## 1. Budawang School – Response to Submissions

ptc. has been engaged by SINSW to address comments received following the State Significant Development Application (SSDA) submission of the Budawang School project located at 17 Croobyar Road, Milton.

This letter has been prepared in response to the letter dated 07/06/2021 from Department of Planning, Industry and Environment (DPIE).

1 BLOCK D PLAN
1:100

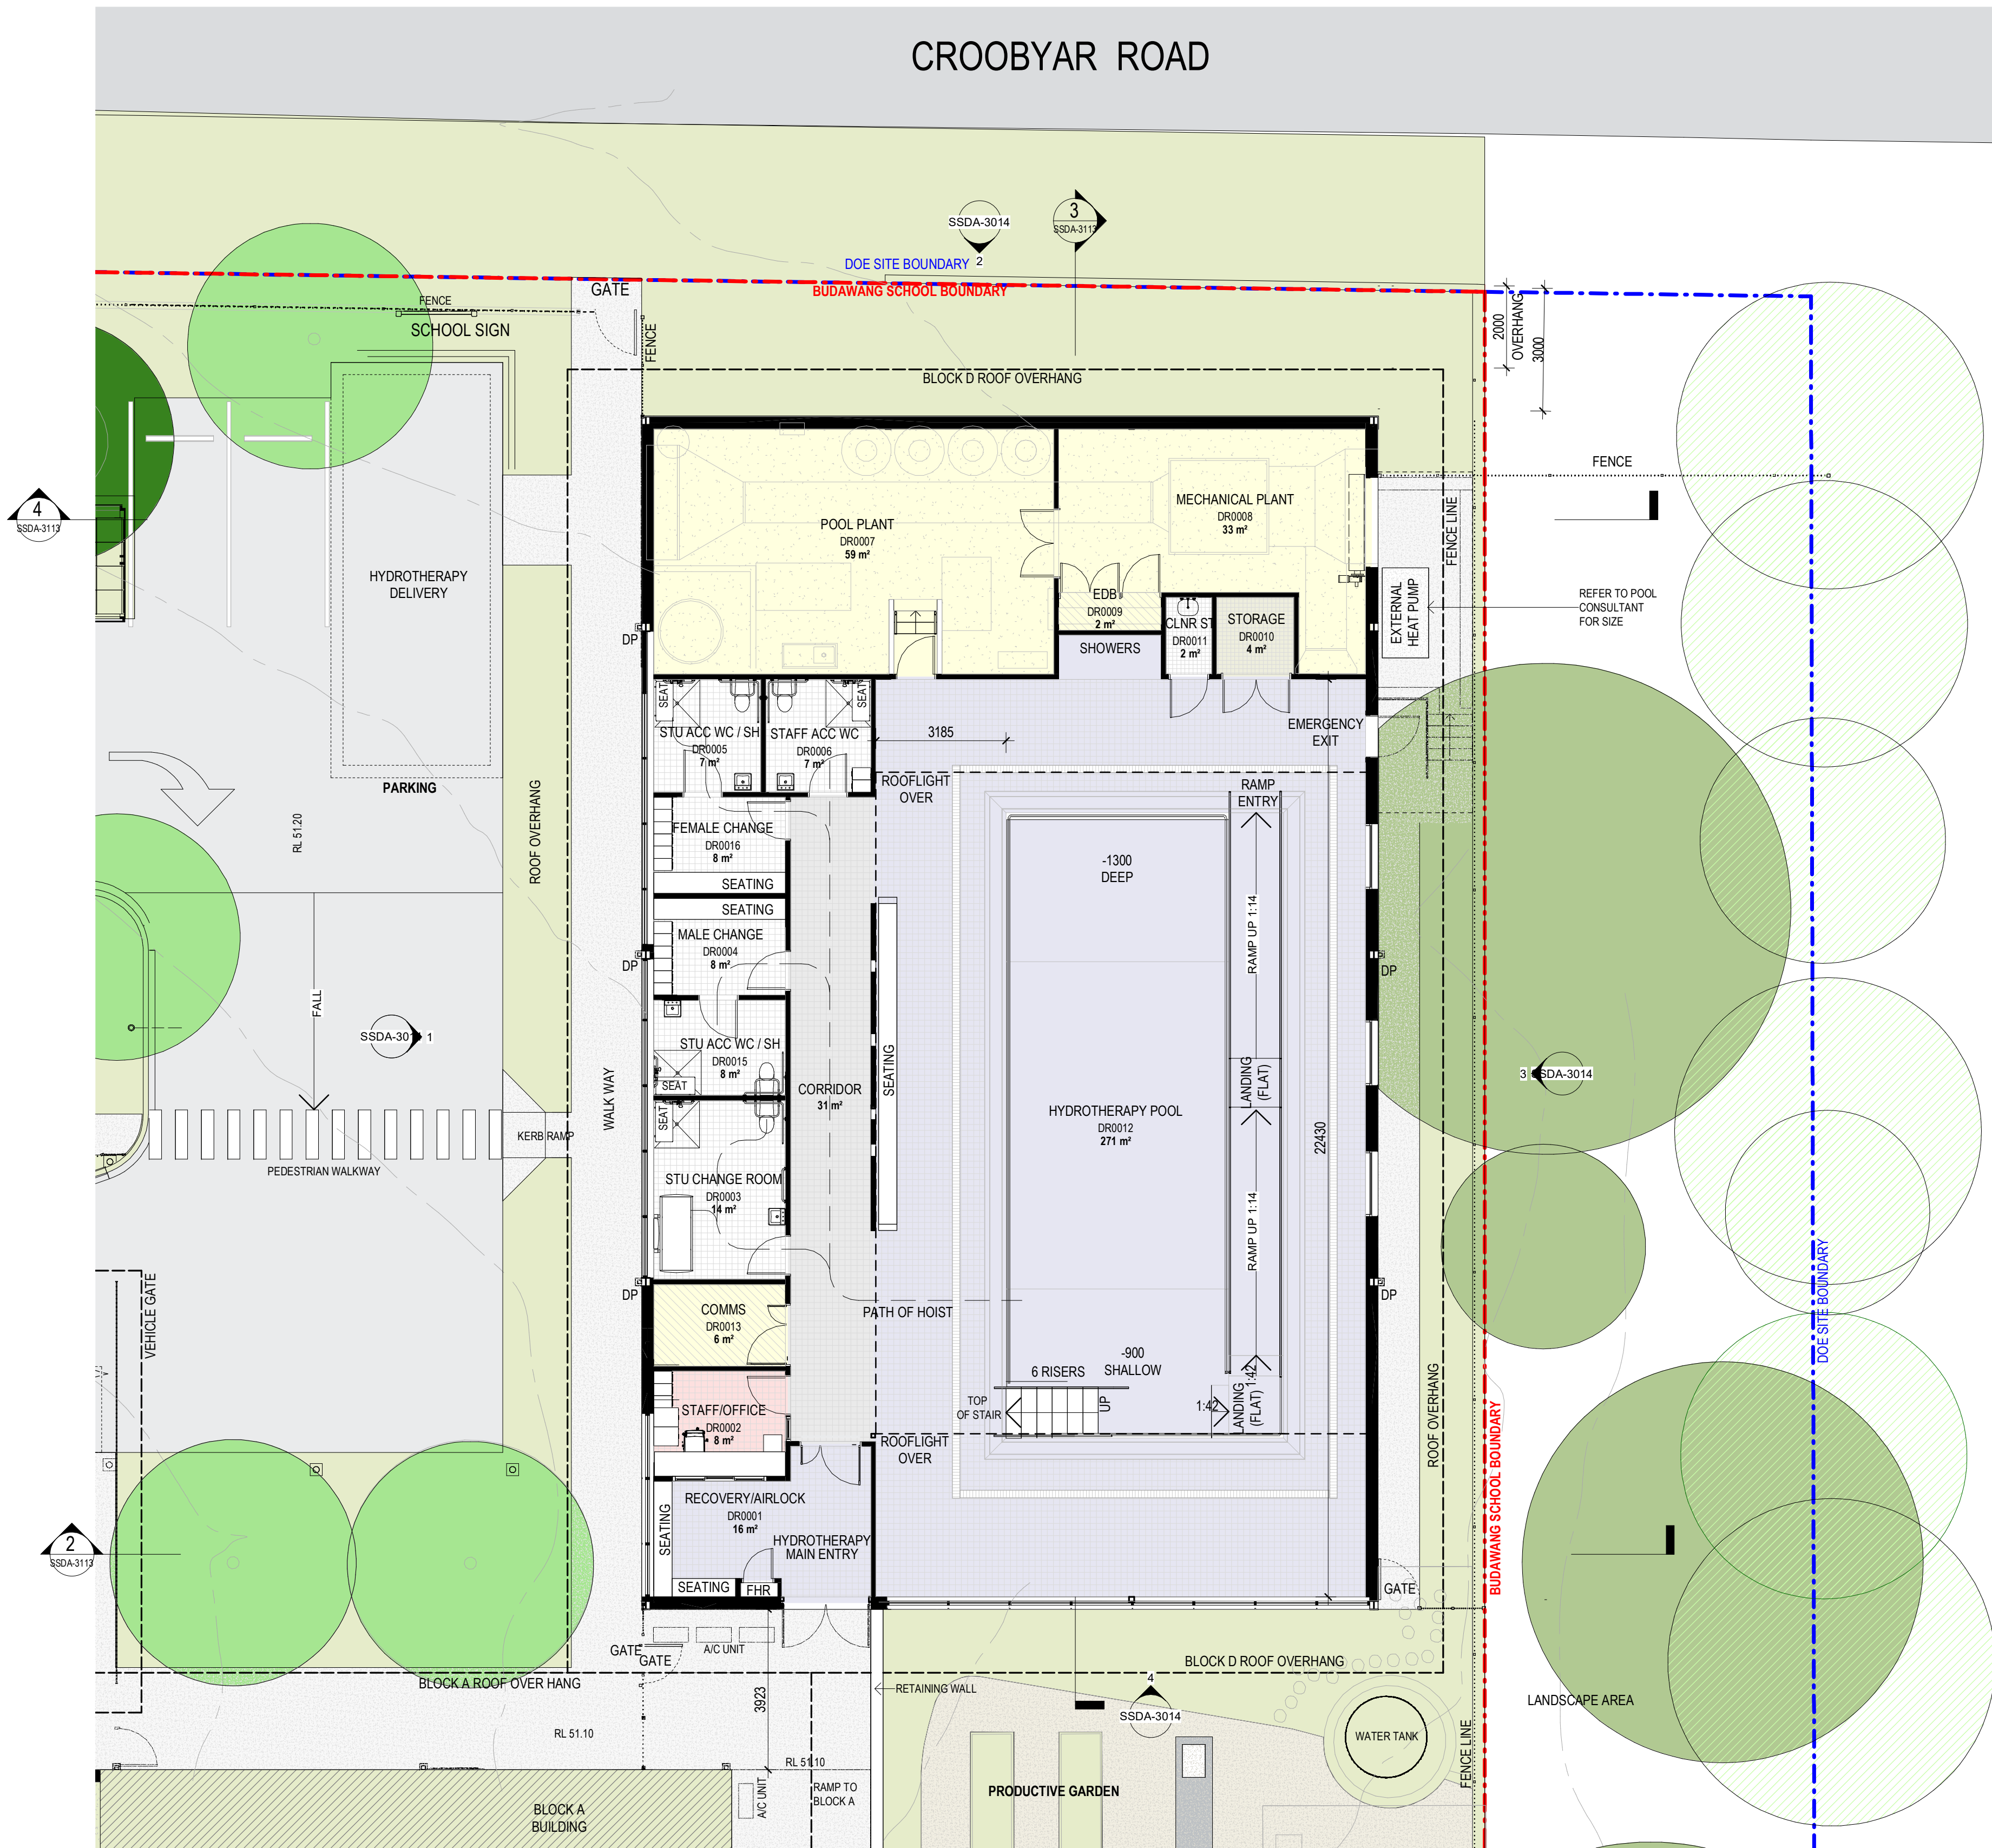
*1. The proposed hydrotherapy facilities (Block D) are proposed for community use outside of the school's standard operating hours. It is unclear where parking would be provided for the public as there is no parking along Croobyar Road. It is also noted there is no pedestrian access along Croobyar Road. Further detail and discussion are required regarding public parking and access associated with the use of the hydrotherapy facilities.*

The hydrotherapy pool would be available for community use after school hours.

Different groups will be allowed access on different days and different times during the week. Upon prior arrangement, these groups will be allowed to access the car park during their use. The travel mode share of the anticipated visitors is expected to be a mixture of private vehicles and minibuses.

The number of users is limited by the size of the pool and it is expected to be up to 20 people at one time.

The proposed car park would have a capacity of 29 spaces, meaning that the parking demand generated by the proposed after-hours use can be accommodated.

Access would be managed by the school based on community user agreements, which will detail the access arrangements as necessary.
